# Rezoning Transportation Analysis

Petition Number: 2022-156

Date	Description
02-23-23	First Review (JLP)
03-23-23	Second Review (JLP)

Drawing file: site-plans / 2022_156_siteplan.pdf

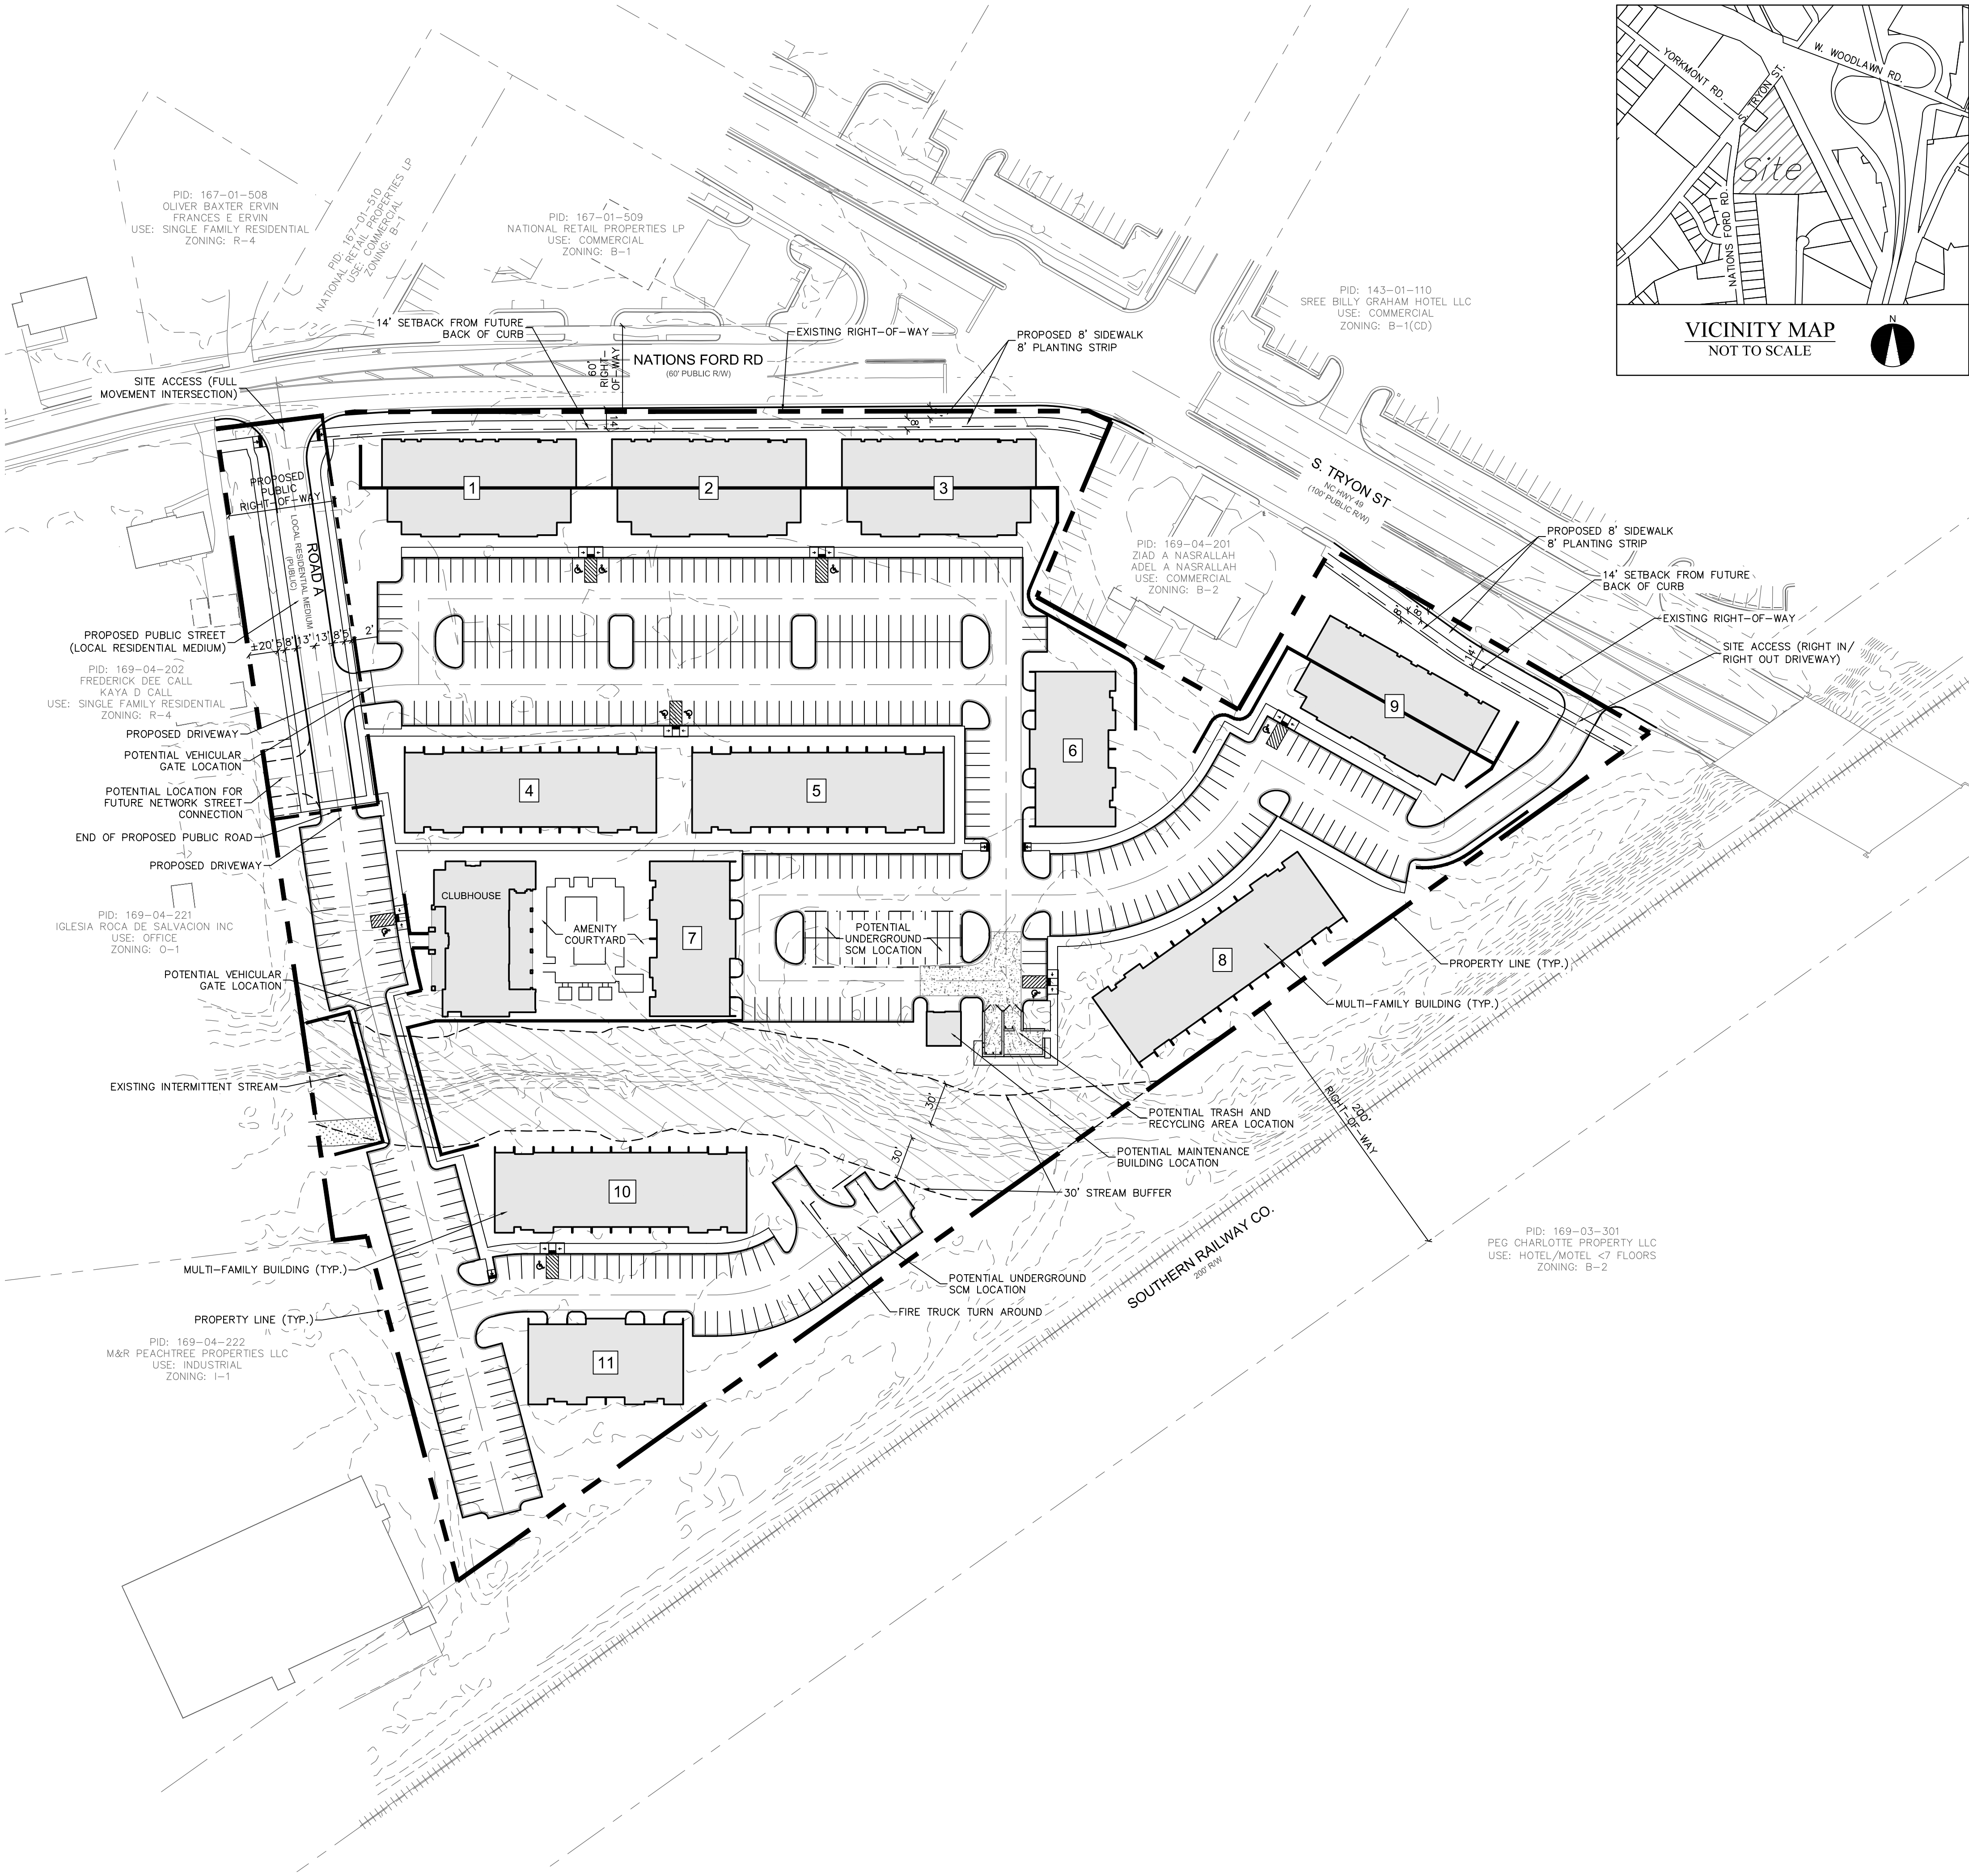
General Location Identifier: 16904224, 16904225, 16904227, 16904228, 16904229, 16904230, 16904201 are needed to dimension the ROW along Public Road A, shift the proposed bike ramp, and to provide a signalized pedestrian crossing across Nations Ford Road.

- Revise site plan to dimension the right-of-way and back of curb on South Tryon Street, Nations Ford Road, and Road A.
- ~~Revise site plan and conditional note(s) to commit to construct bicycle facilities on South Tryon Street by installing a 12' multi-use path to meet the Council-adopted Charlotte BIKES Policy. Multi-use paths maintained by the City shall meet ADA/PROWAG requirements.~~
- ~~Revise site plan and conditional note(s) to commit to construct buffered bike lane bicycle facilities on Nations Ford Road by locating the curb and gutter 27' from the center line to meet the Council-adopted Charlotte BIKES Policy. Multi-use paths maintained by the City shall meet ADA/PROWAG requirements. Provide bike ramp along Nations Ford Road near South Tryon Street to transition from the buffered bike lanes to the multi-use path on South Tryon Street.~~

**Clarifying Comment 3/22/23:** Shift bike ramp to precede the pedestrian crossing, extend MUP to new ramp location.

Revise potential gate located to  
be a minimum of 40ft from the  
proposed right of way

15. **CDOT REQUEST** – Under future UDO guidelines this project would require a Comprehensive Transportation Review and mitigation. In lieu of providing CTR, CDOT REQUESTS the petitioner provide a signalized ped crossing at Nations Ford Road at the existing traffic signal. This will help with safe pedestrian circulation at the intersection which currently does not have any pedestrian accommodations. There is a City CIP project that is installing 2 additional crossings at this location, but because there was not sidewalk on the development site, they did not provide a crossing.
